Application Reference: 2026/0033

Site Address: 3 Rydal Close, Penistone, Sheffield, S36 8HN

Introduction: This application seeks full planning permission for a single storey front extension, 2 storey rear extension, demolition of detached single garage, erection detached garage

Site Plans - PROPOSED

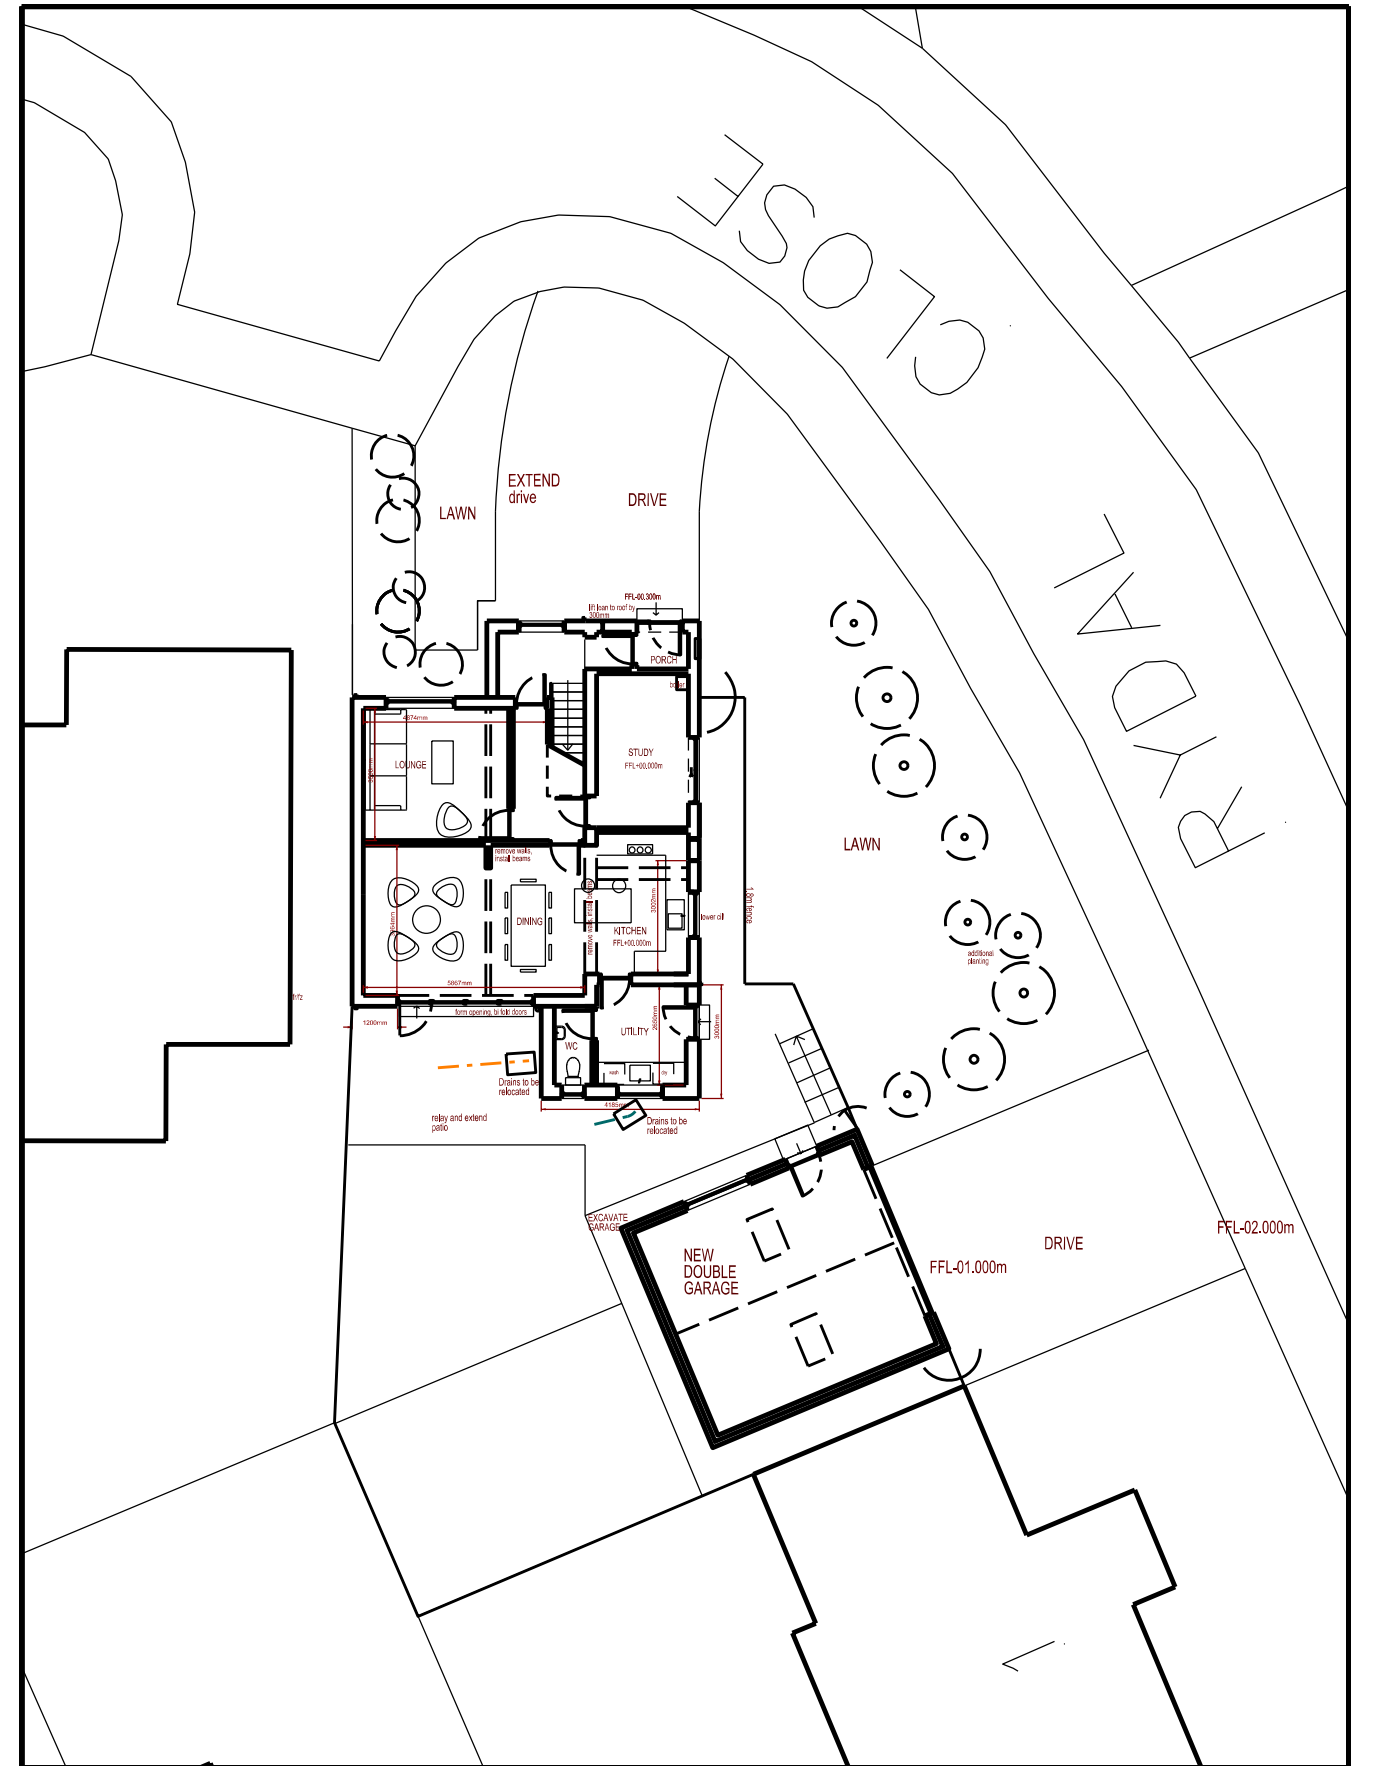
Starting with the garage, the proposed demolition of the original garage has already occurred and construction of the replacement garage has started. With the garage scale and design mirroring that approved in application 2025/0254, once completed the garage would have no further impact on the design, scale or character of the dwelling that what was originally assessed and subsequently approved in application 2025/0254.

The proposed extension on the front elevation would create an approximate 5.3 sqm of additional living or utility space. This small addition would be attached to the existing front projection which, along with an extended driveway, was also approved in application 2025/0254, although these specific two alterations may have been eligible for completion through permitted development rights.

In addition to its modest scale, the proposed front extension would be incorporated well with the existing design of the house, being sited at the location of the current front door which was approved previously, to be replaced by a window and proposed open porch/bin storage area under an existing canopy. As previously approved and again shown in this application, is for a new front door to replace the current integral garage door, unlike the proposed porch this could also be completed through permitted development. Featuring a projection of approximately 2m, the proposed front extension would not extend beyond the projection of the original integral garage and would appear to be one single porch style extension to the dwelling.

Drawing Title: Elevations - PROPOSED

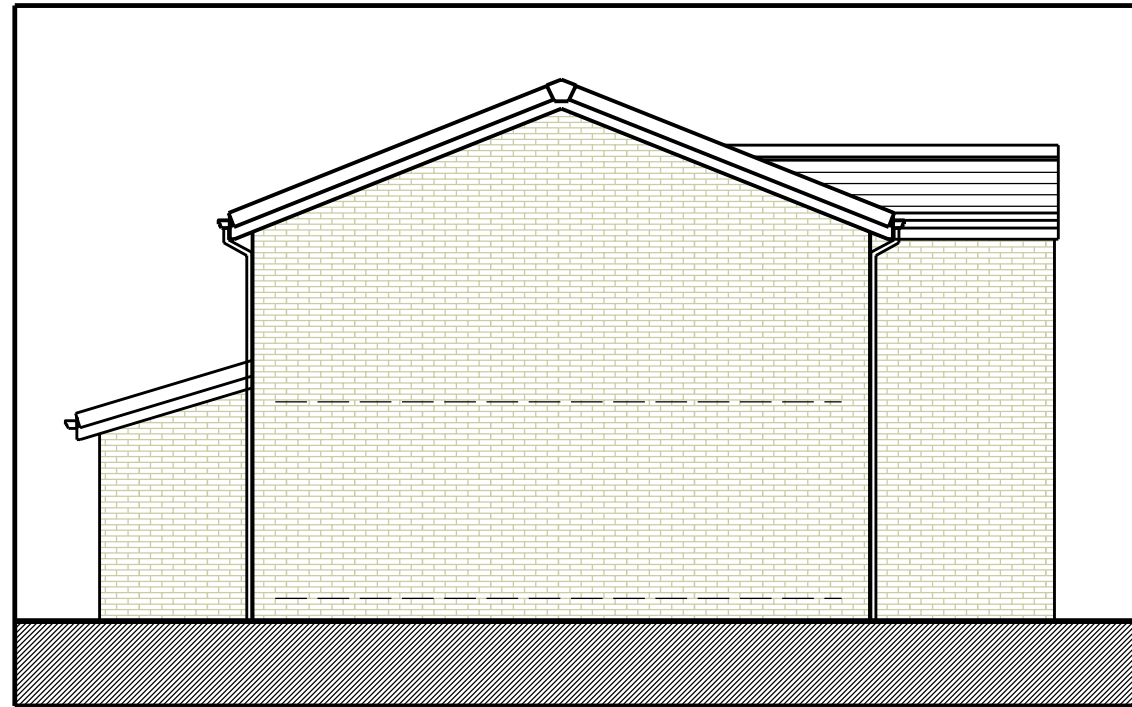
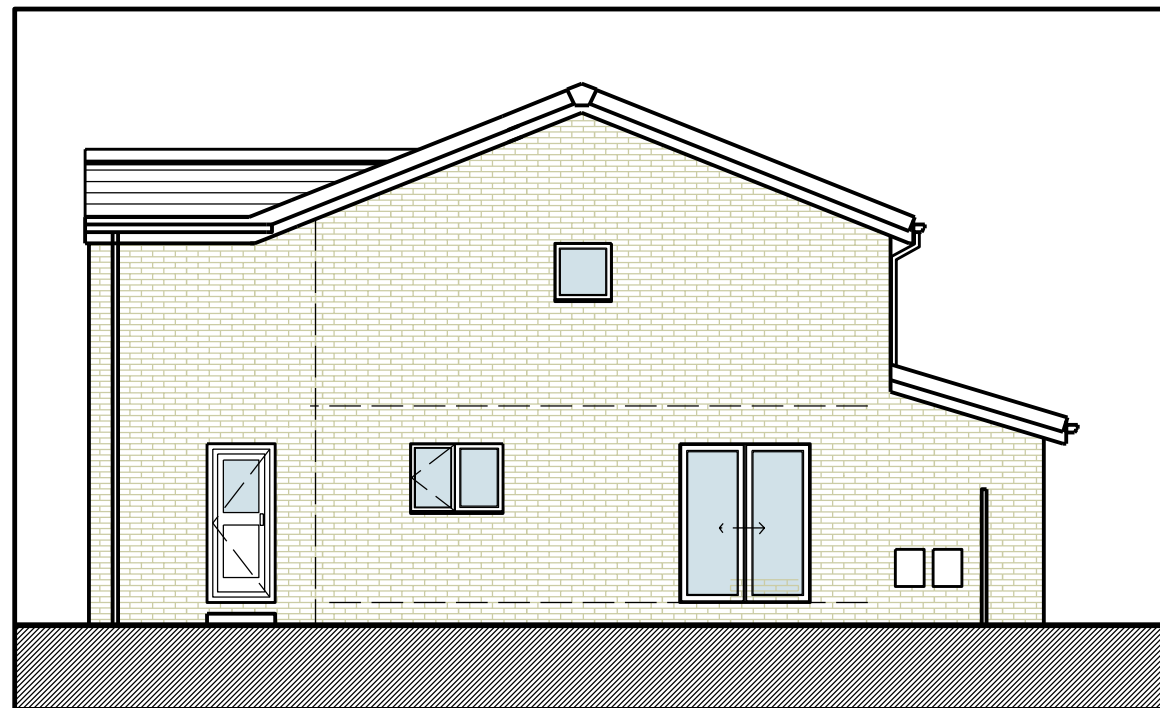
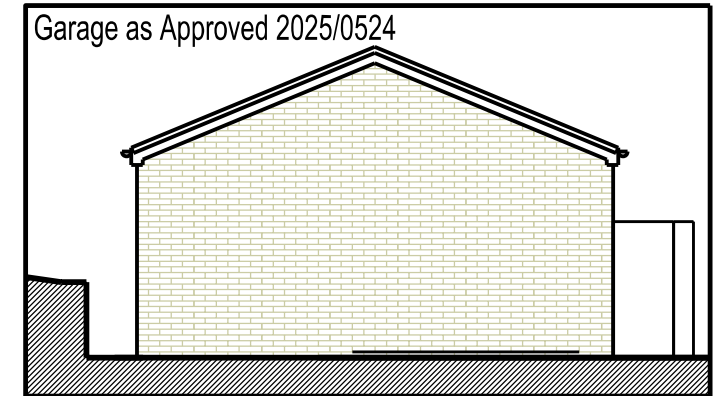
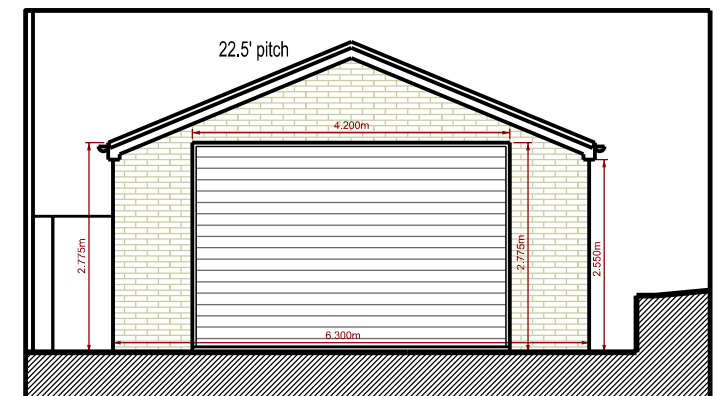
The proposed two-story rear extension, which remains prominent within the side elevation view, is much smaller and less imposing than the proposed two-story extension refused in application 2025/0270. Whilst the ground floor footprint of the dwelling would be extended by just under 12 sqm, with a maximum rear projection of 3m, the first-floor extension, due to the unique design of the house would feature a floorspace increase of approximately 19.5 sqm, with maximum projection of 5.3m. Despite these seemingly large rear projections, from the principal bulk of the rear elevation, the rear projection would not exceed 2.45 sqm.

Whilst there is not expected to be a significant impact on the scale of the house, created by the rear extension, or technically rear and side elevation, due to the staggered rear extension, there would undoubtedly be an impact on the design and consequently the character of the house. With the unusual design of the house though, it is debatable whether this impact would be negative, or as was considered for the original, albeit a smaller first floor extension, unification of the rear elevation to look more comparable to a traditional style two storey semi-detached house.

With the two-storey rear extension, whilst it may have an impact on outlook from nearby neighbours, this impact would be considered as modest and would not pose any significant harm to their amenity. There may also be small impact on light levels for No 5, but again not anything which would require amendment to be acceptable.

With nothing more than a limited impact on neighbouring amenity, with the proposed windows on the two storey rear extension at an angle to neighbouring properties to the rear, and sufficient distance away from them, to avoid any significant overlooking, the proposal would be considered in accordance with Local Policy GD1 which carries moderate weight in favour of the proposal.
